SSD 6917 - INNER SYDNEY HIGH SCHOOL

SUPPLEMENTARY RESPONSE TO SUBMISSIONS

title
Sun Studies
Proposed December 21st

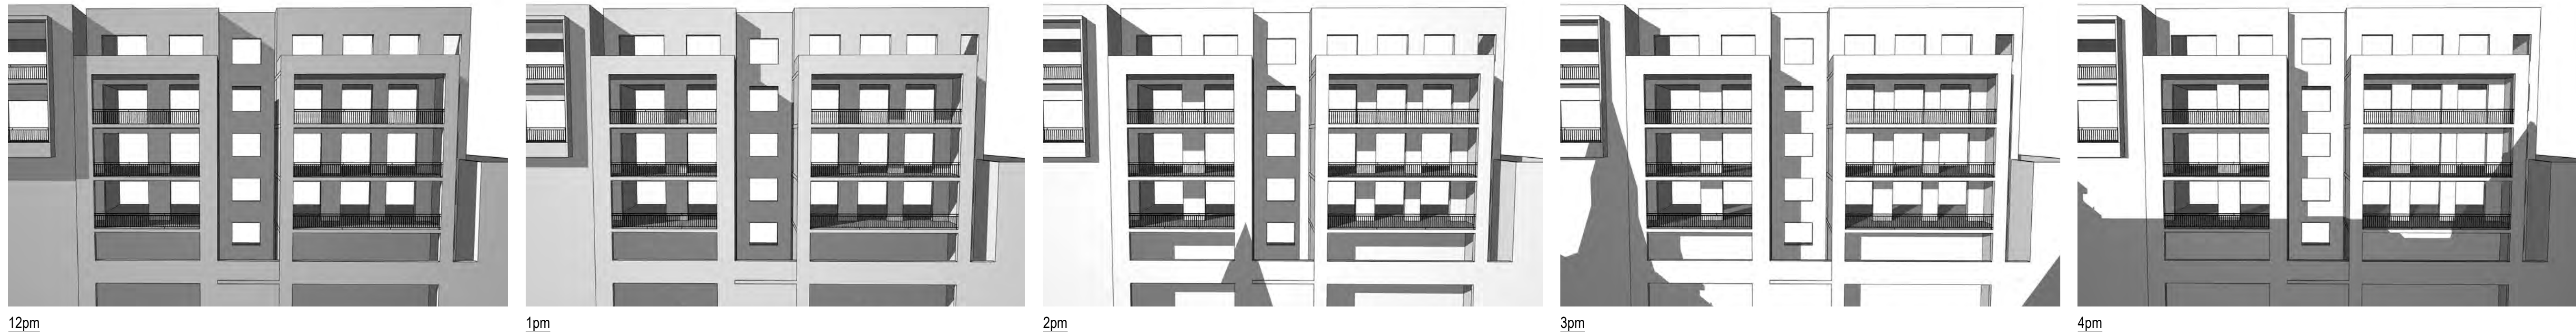
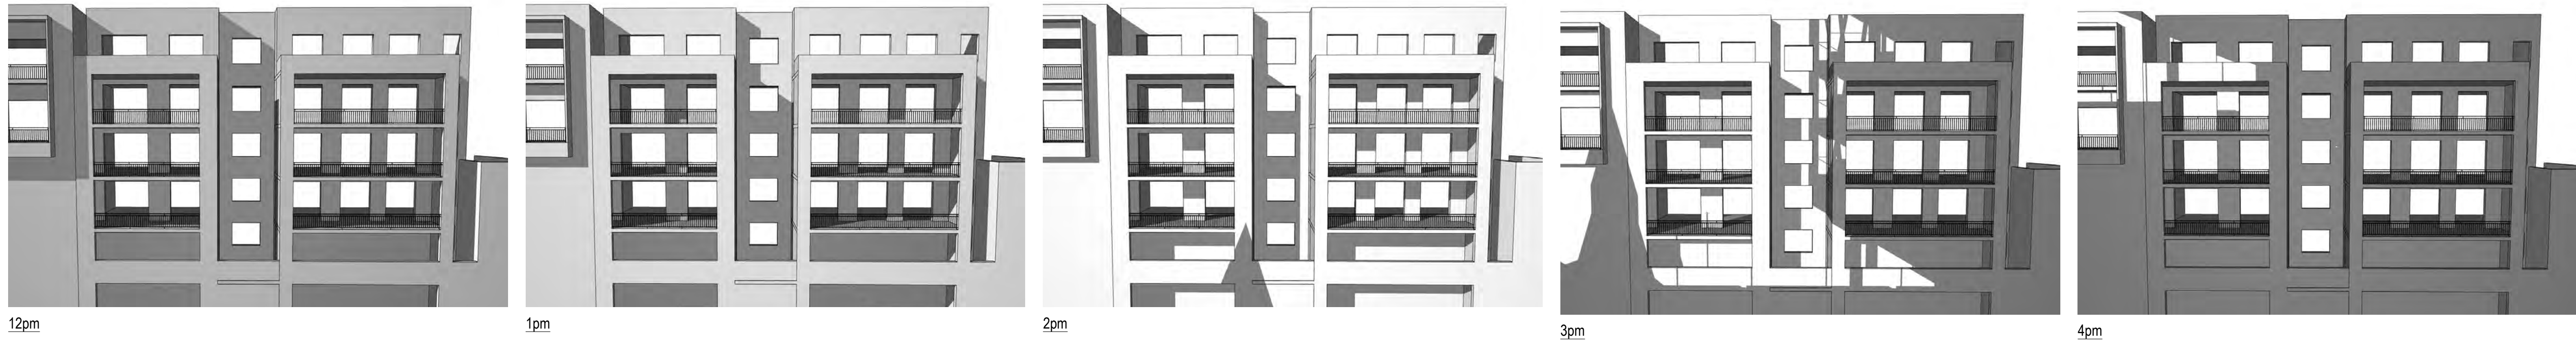
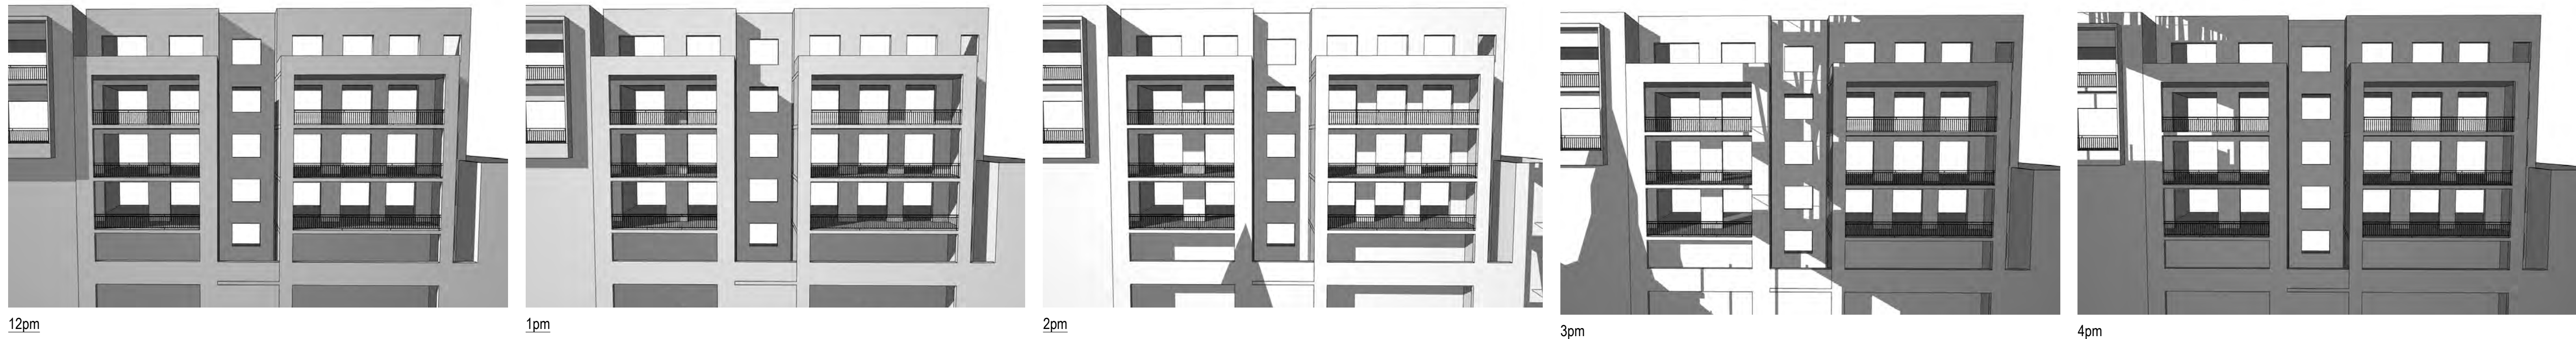
<p>building as it will primarily supply science labs and low flow tapware". This may understate standing losses and, if hot water is reticulated to all staff and student bathrooms (this is not mandatory) there are extensive hot water pipe chases which will trigger hot water draw down. Solar (evacuated tube recommended) with controlled boosting or heat pump water heating is recommended.</p>	<p>considered. The proposal is to proceed with the current solution in view of DoE's interest.</p>	
Overshadowing	<p>The drawings are unclear in that shadow falling on glazing of 204-214 Chalmers Street is not identified. However, it is clear that the west facing apartments in the south west corner of this building are impacted at 3pm. At midday, the angle of sun is too oblique to the facade to be of any effect. These apartments therefore rely on solar access from some time after midday (possibly 12:30) for the following two hours. In the existing condition, they are compliant.</p> <p>In the proposed condition, the material submitted shows that solar access is lost at 3pm. This impacts two apartments each at level 1 and 2, and 1 apartment at levels 3, 4, and 5. Without the half hour views, it is not possible to conclude whether these 7 apartments change from a complying to non-complying status. The Department should satisfy itself whether the reduction in sunlight hours results in a solar access non-compliance or not, and whether the resultant amenity is acceptable.</p>	<p>Half hour shadows have been prepared from 12.30pm. There is no additional shadow at 12.3pm and 1.30pm. There is some additional shadow at 2.30pm. There is no impact on 204 Chalmers Street until 2.30pm. This property will not be impacted by the proposal in the morning, midday and early afternoon hours.</p>	<p>Refer to Appendix C</p>

title  
Landscape  
Landscape Sections

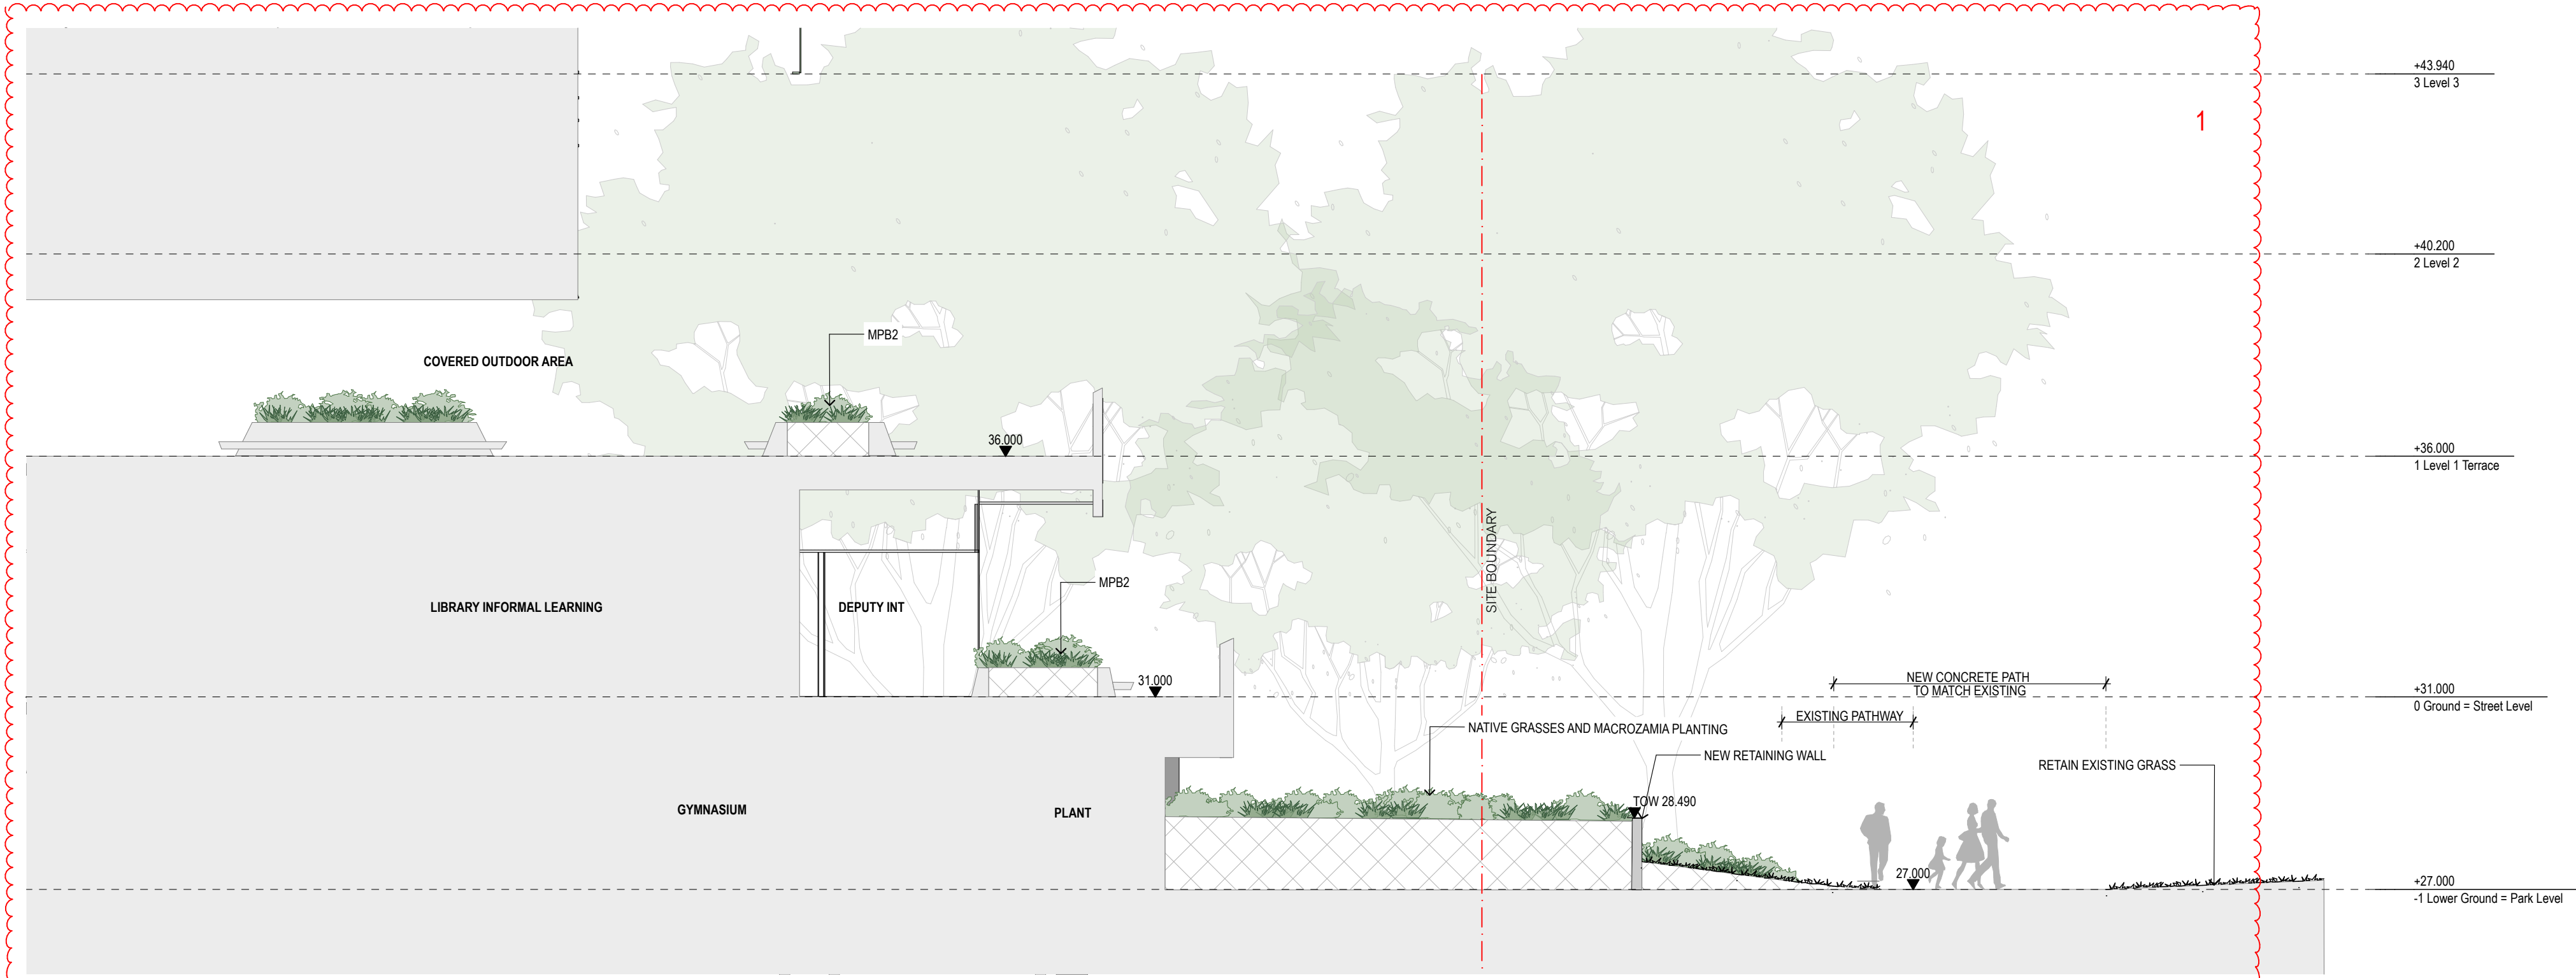
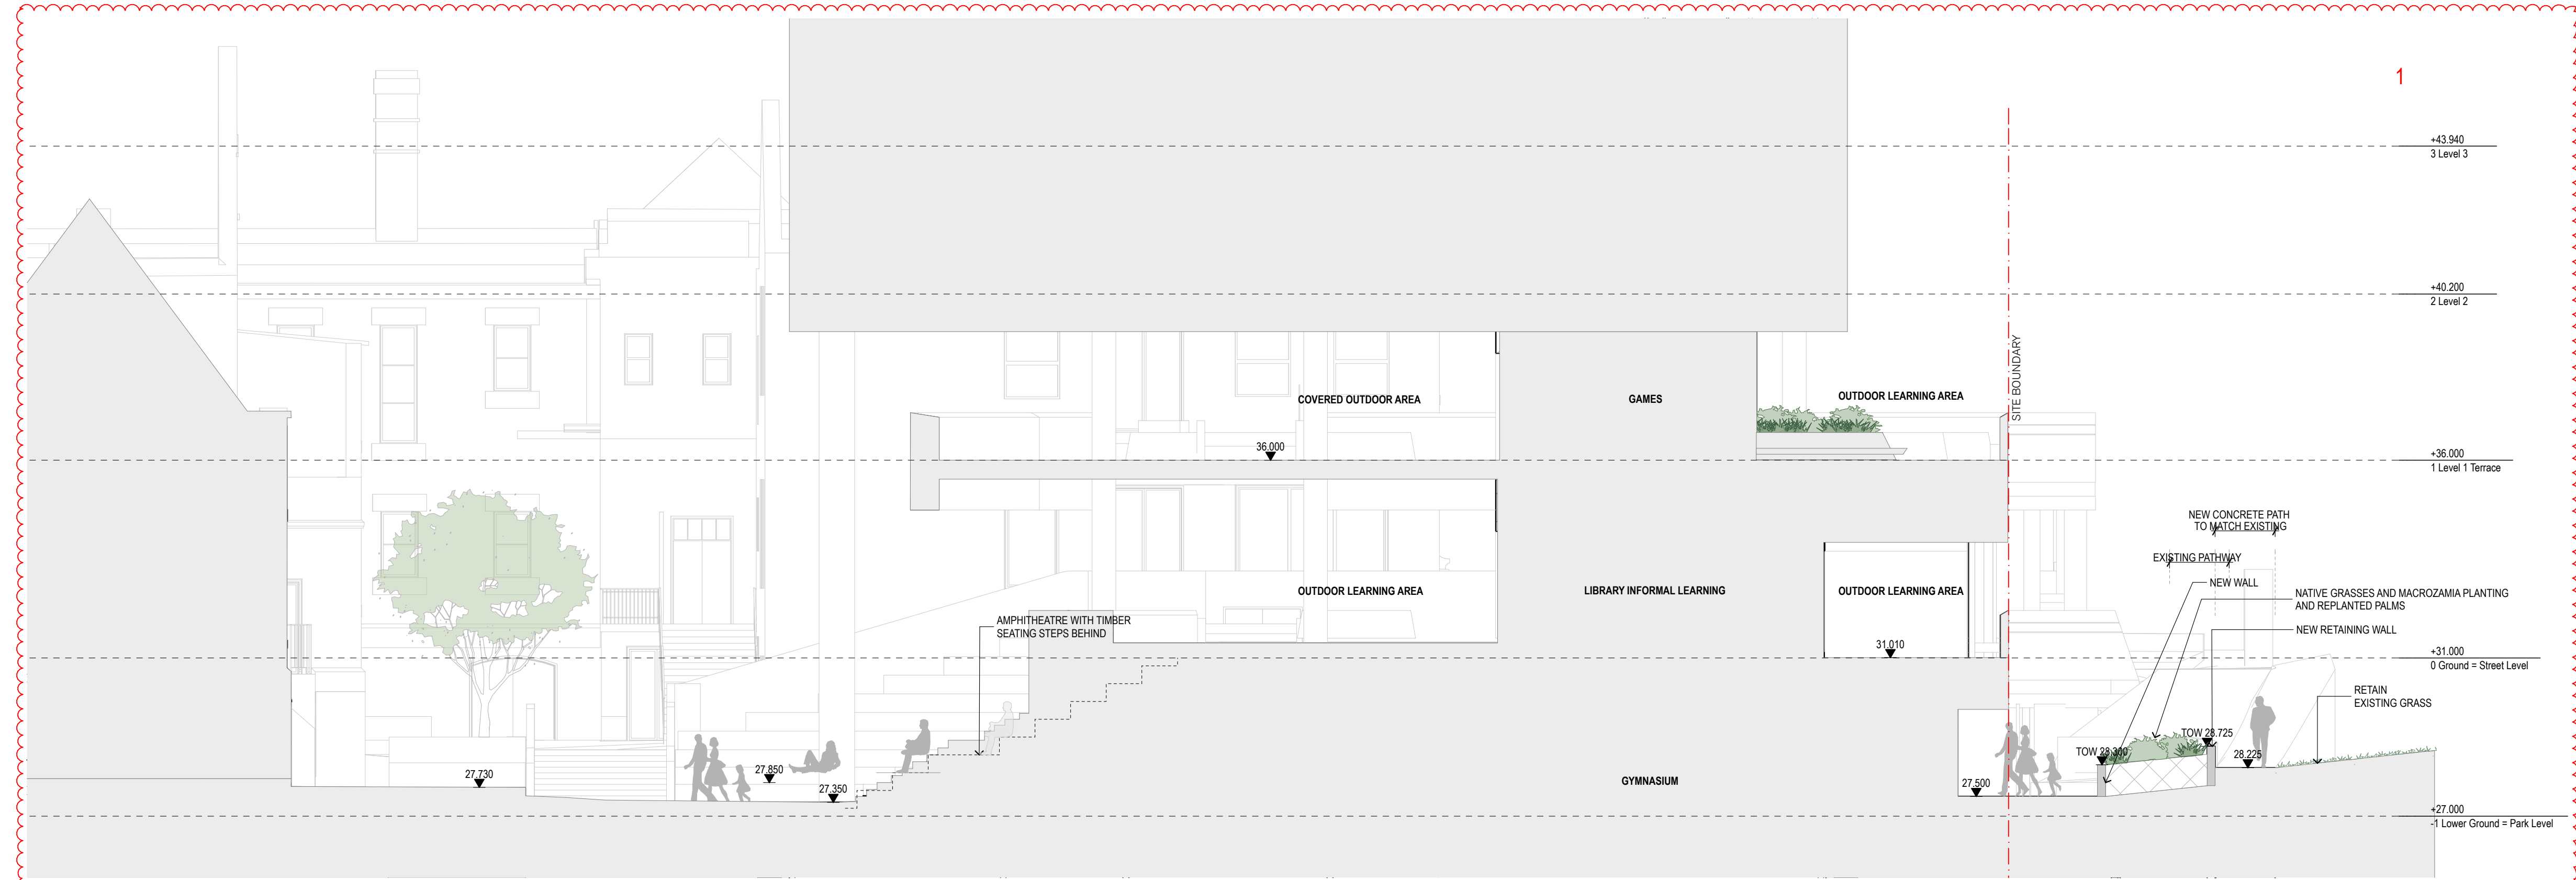
Prince Alfred Park Interface	<p>The RtS relies upon land within the park to redefine the overland floor paths, and to mitigate level changes and access requirements between the proposed buildings and the park. These works include the introduction of terraces/retaining walls, a seating wall, and planting that does not tie into the existing park palette. These works are</p>	<p>Prior to the submission of both the SSD Application and the Response to Submissions, the Project Team have discussed the implications of the flood mitigation with Council. Council has given support to the proposed flood mitigation strategy, which includes a series of low walls and planting. The material palette and the planting palette are consistent with Prince Alfred Park. fjmt will continue to</p>	Can be conditioned
